Our Ref: SB-MTWQ1

Portishead Branch Line – MetroWest Phase 1

Below are the North Somerset Levels Internal Drainage Board's answers to the Examining Authority's written questions and requests for information (ExQ1) Issued on 26 October 2020.

Drawing
**PORTISHEAD STATION CAR PARK
LAYOUT, LANDSCAPING AND NEW
BOULEVARD AND ACCESS PLAN
SHEET 1 OF 3**

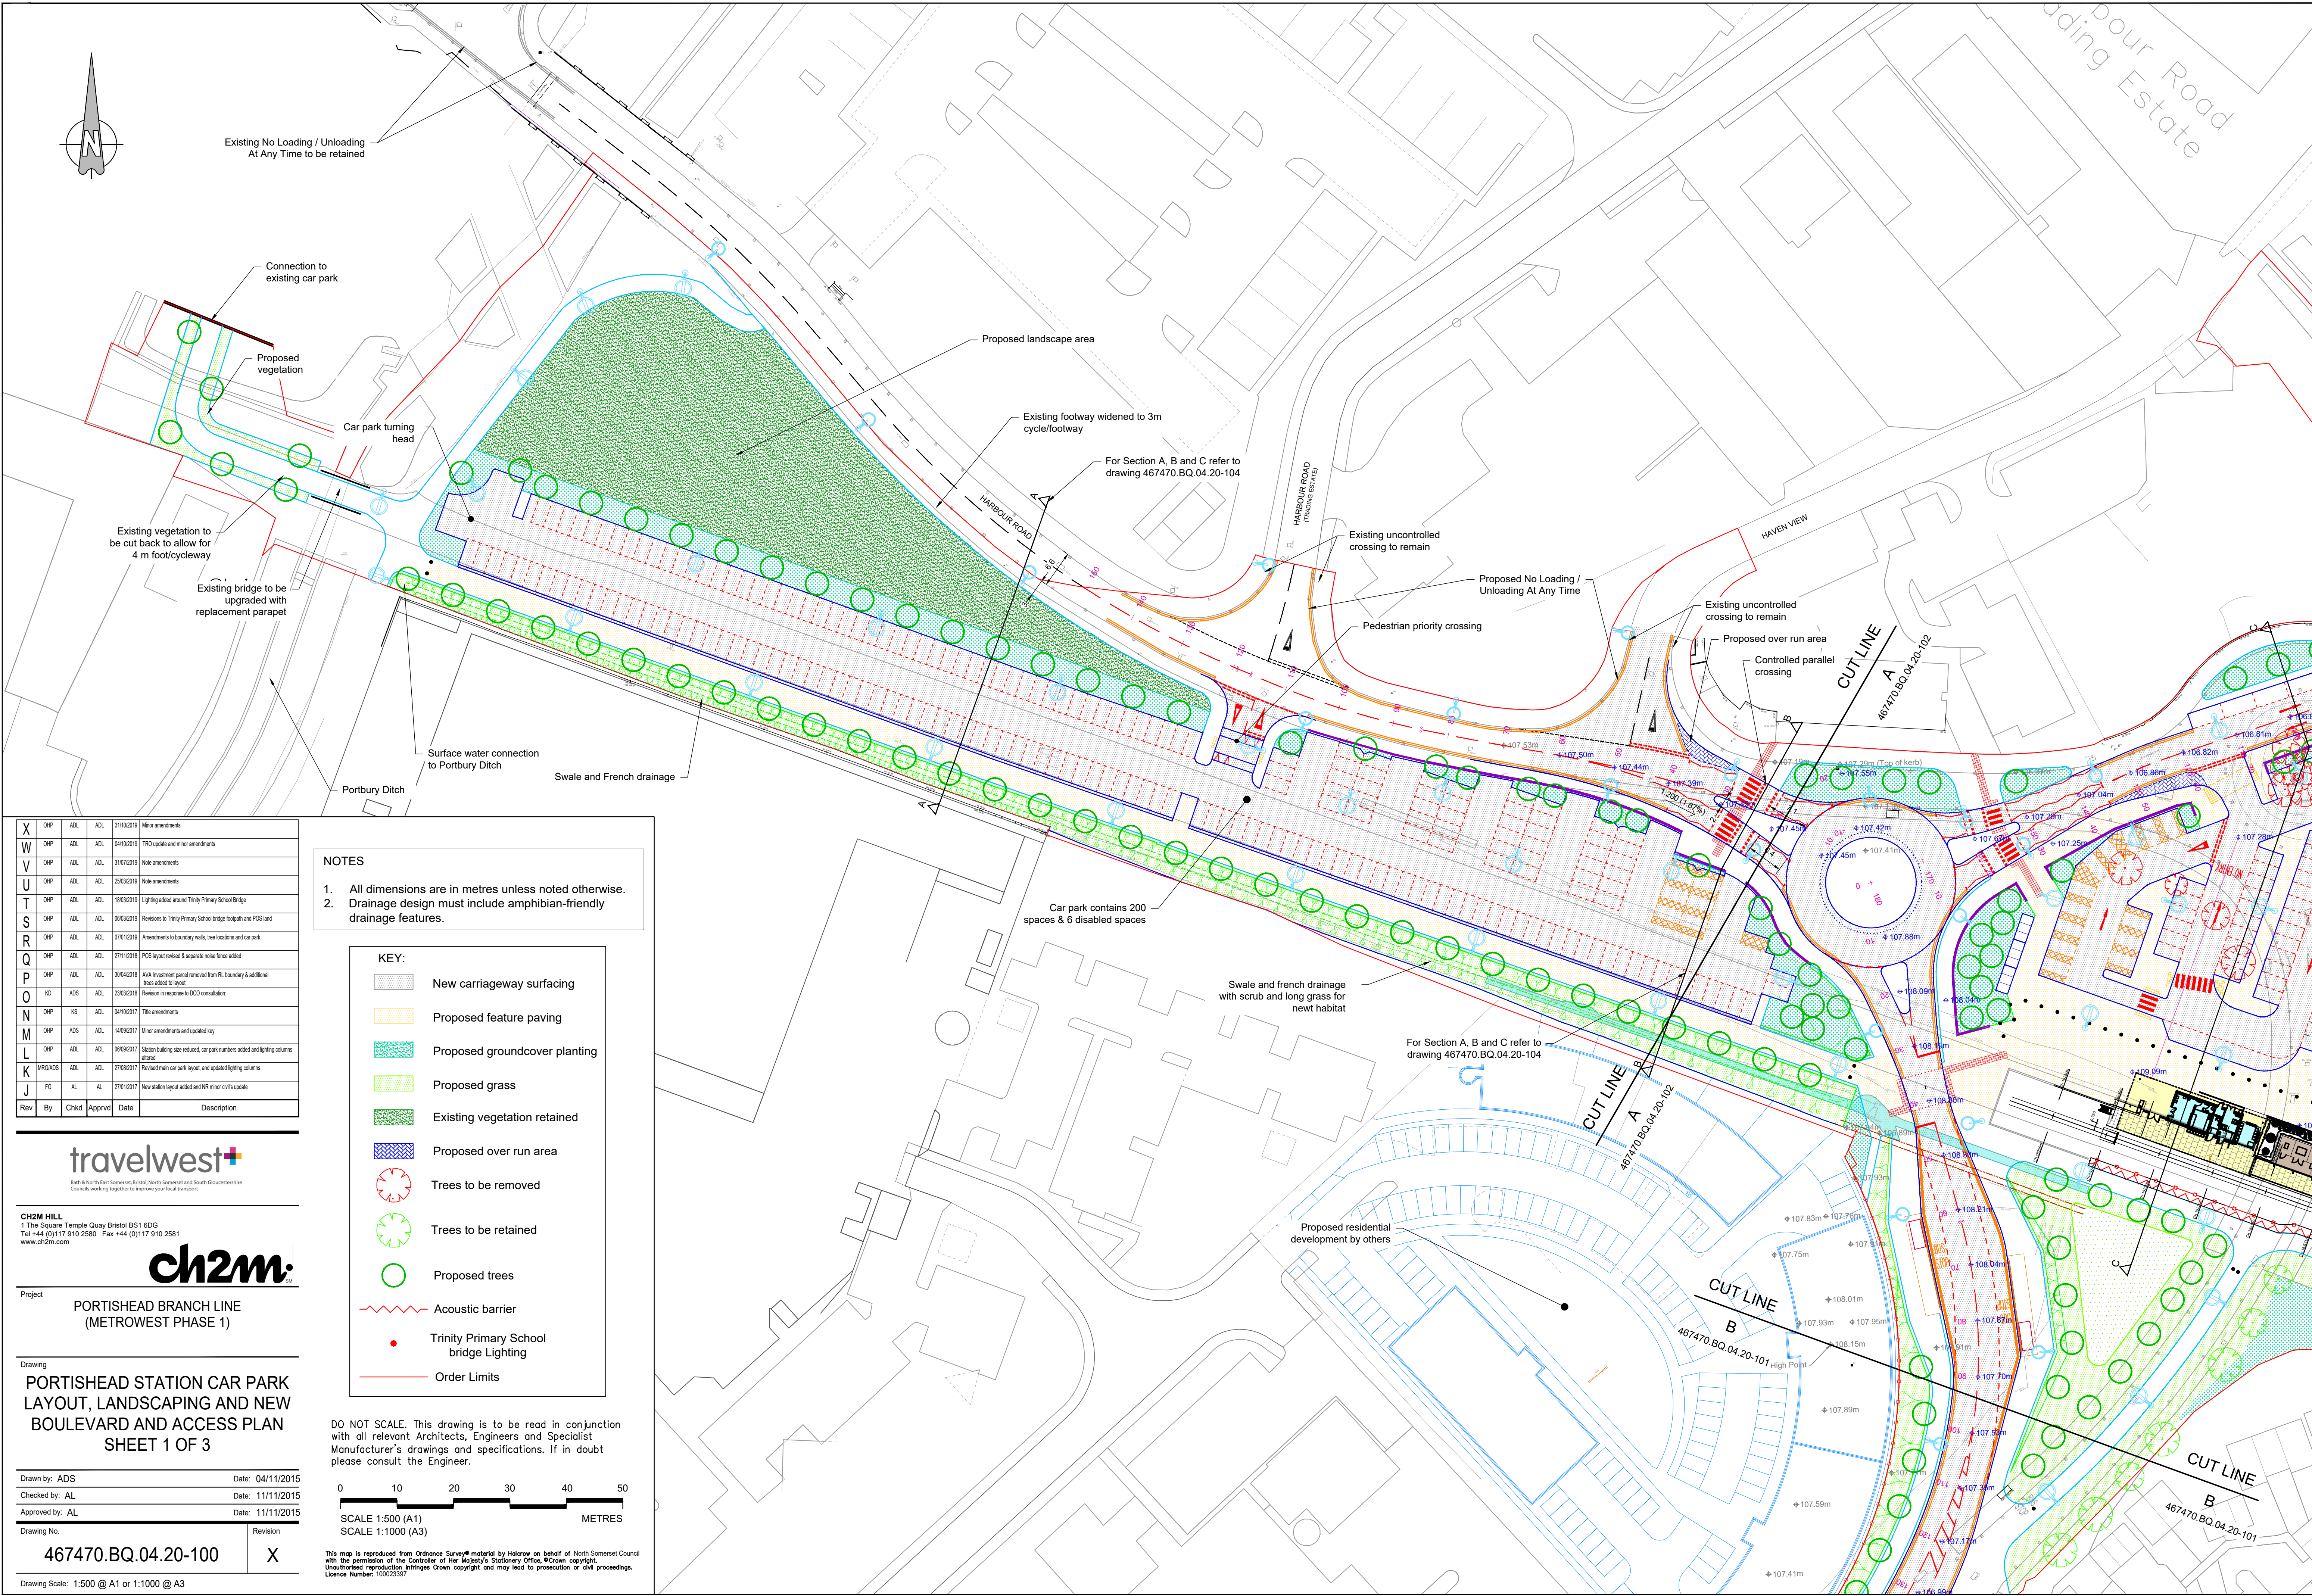
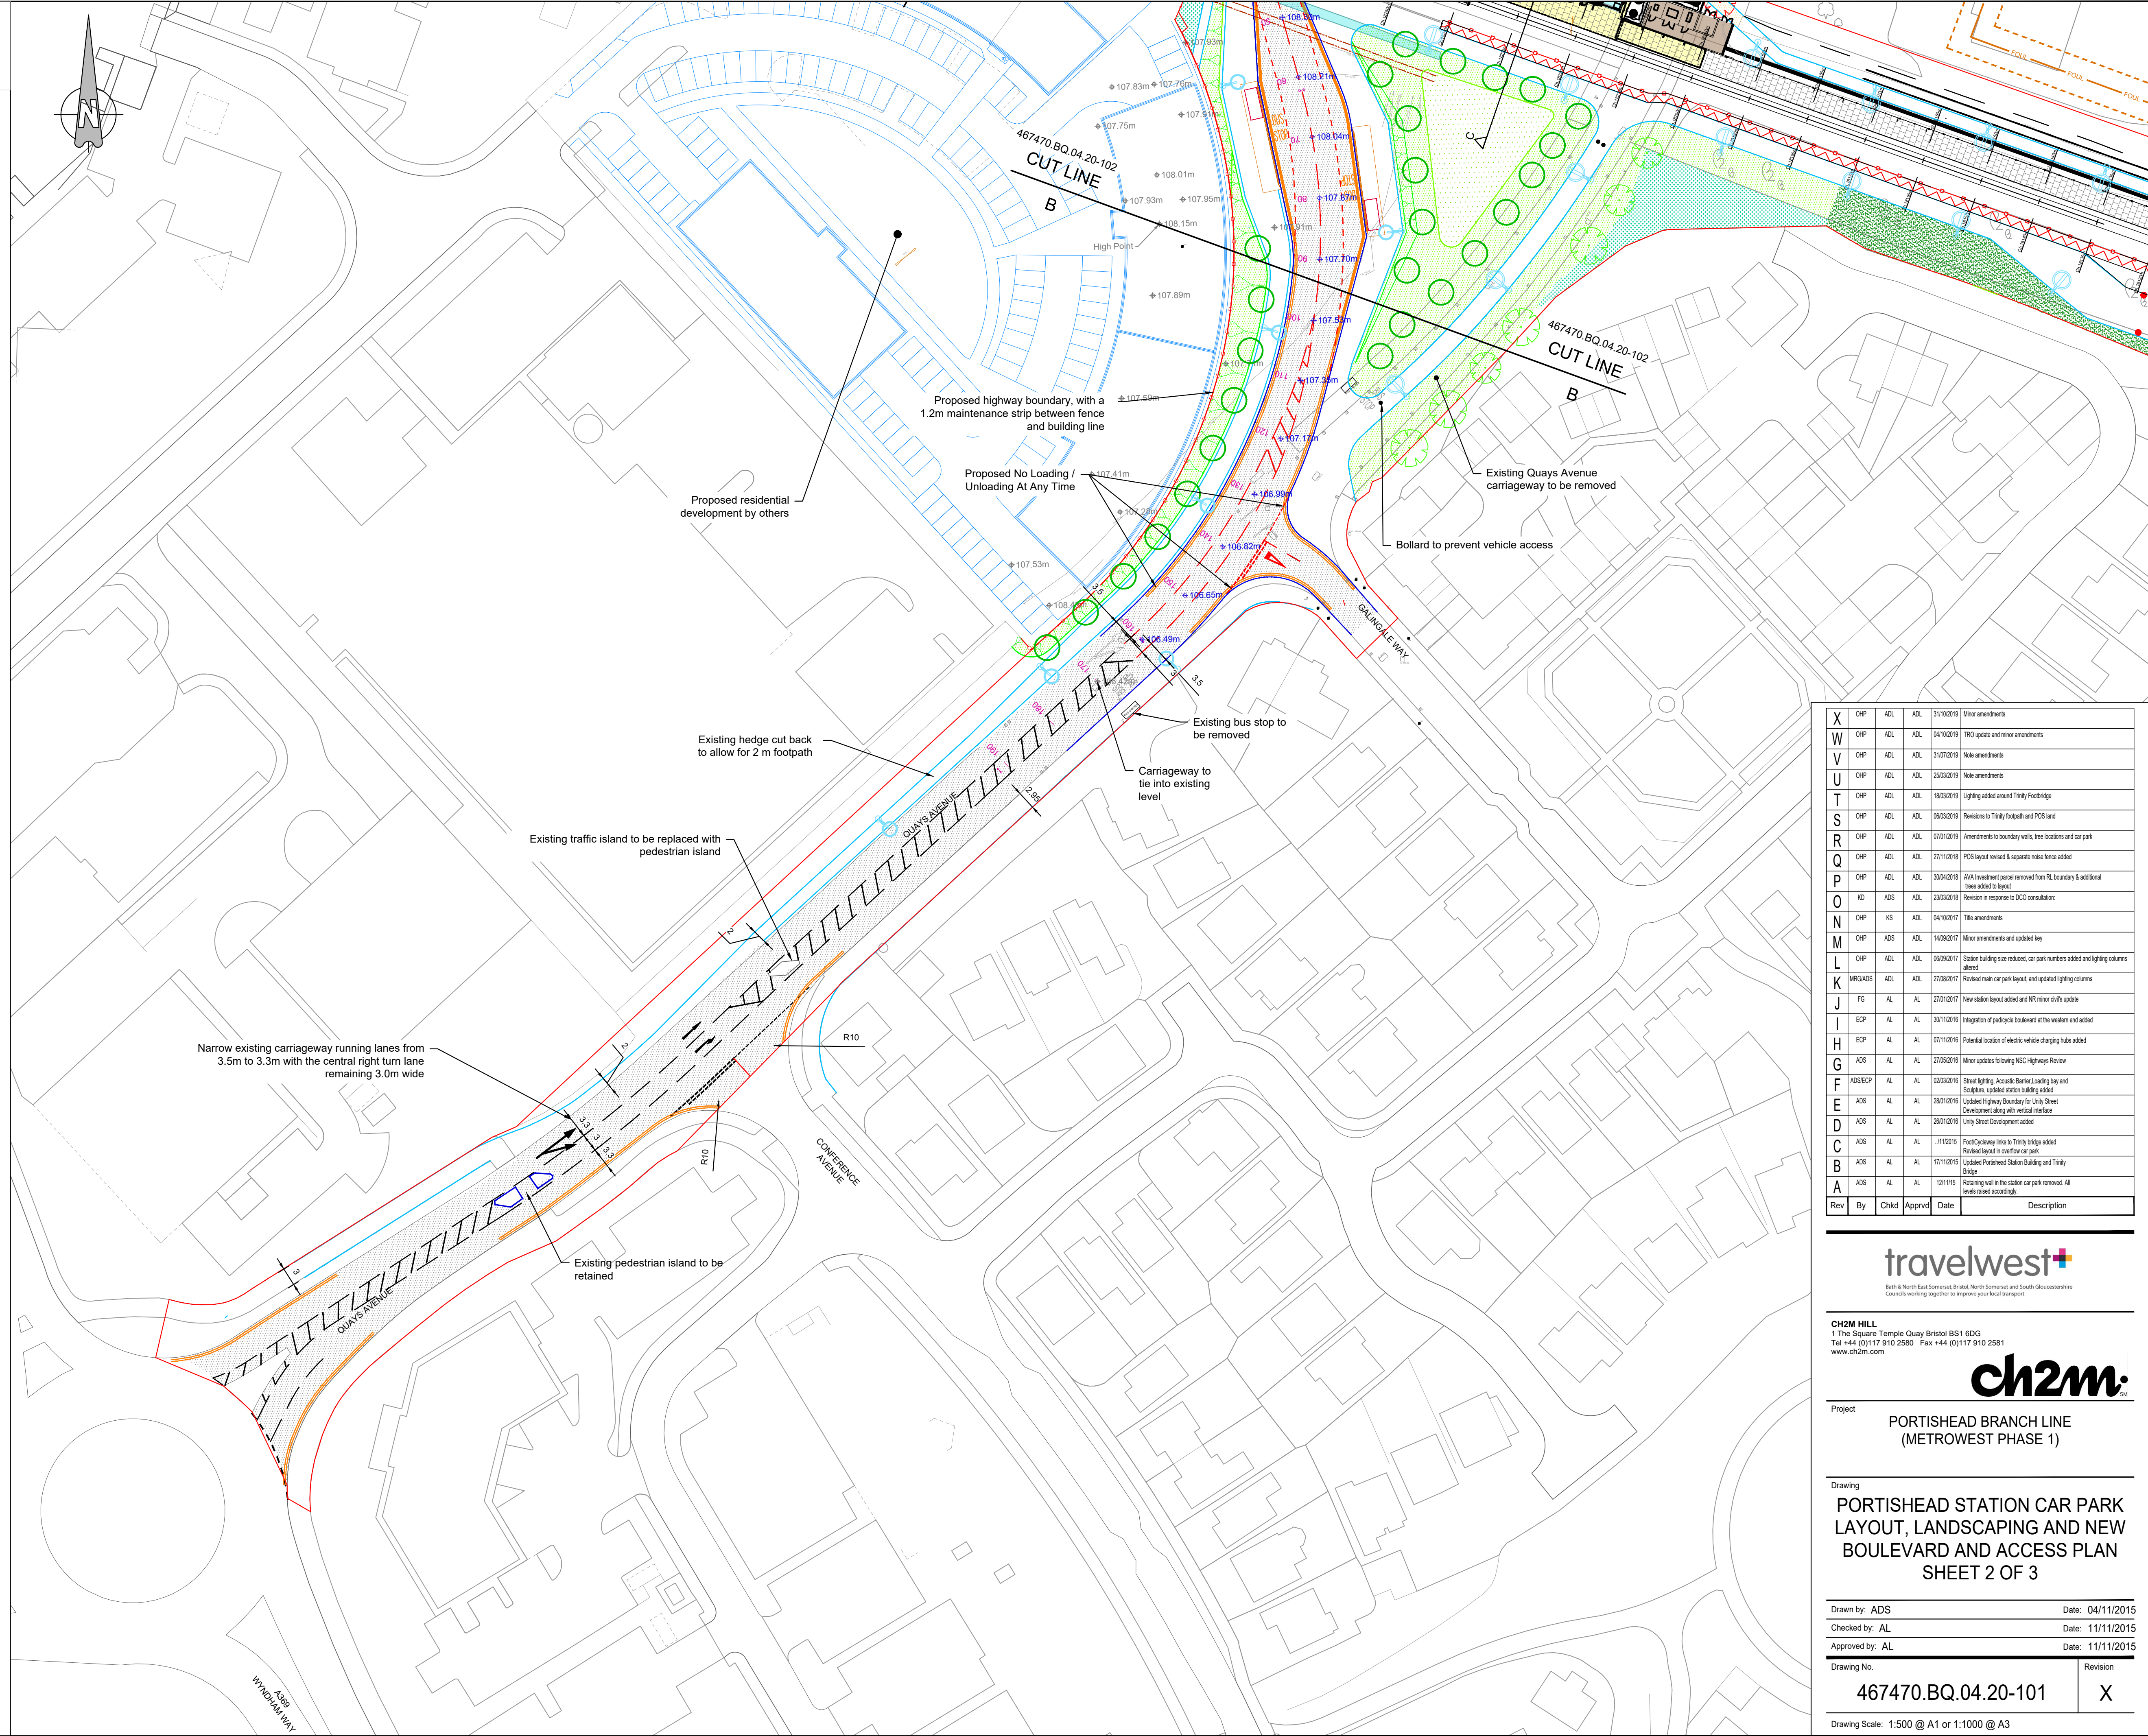
In the location of the Portishead station footbridge and the Board's maintained watercourse known as The Cut (between Galingale Way and Tansy Lane), the applicant's current drawings are partly based upon ordnance survey mastermap data which only is accurate to the nearest metre, and individual features such as watercourses are not accurately surveyed. The top of the bank (a position which is critical when considering safe operational maintenance activities) is not shown. The Board would wish to see a topographical survey of the watercourse undertaken and a more accurate drawing and cross-section of this area provided. This will enable a precise assessment of the space between the top of the watercourse and the railway fence to see if there is enough space for the Board to undertake its statutory duties. For safety reasons, this surface must be flat, and the current drawings do not provide enough level information to determine if this can be achieved. The Board would also want further detail on any street furniture including lighting columns, kerb details, proposed tree species and associated tree pit details. The applicants drawing 467470.BQ.04.20-SK110 rev 8 also incorrectly refers to the batter of a watercourse as being an 'area of grass suitable for excavating vehicle to occupy' which clearly it is not as the drawing does mark the top of the bank (ToB).

The Board has no issues with the railway fence in the location shown in red on 467470.BQ.04.20-SK110 rev A and that provides a similar (not the same) level of access to which the Board has now, but this is subject to the detailed design of the landscaping, lighting, surfacing, levels and any non-network rail fencing and the accuracy of the currently presented information.
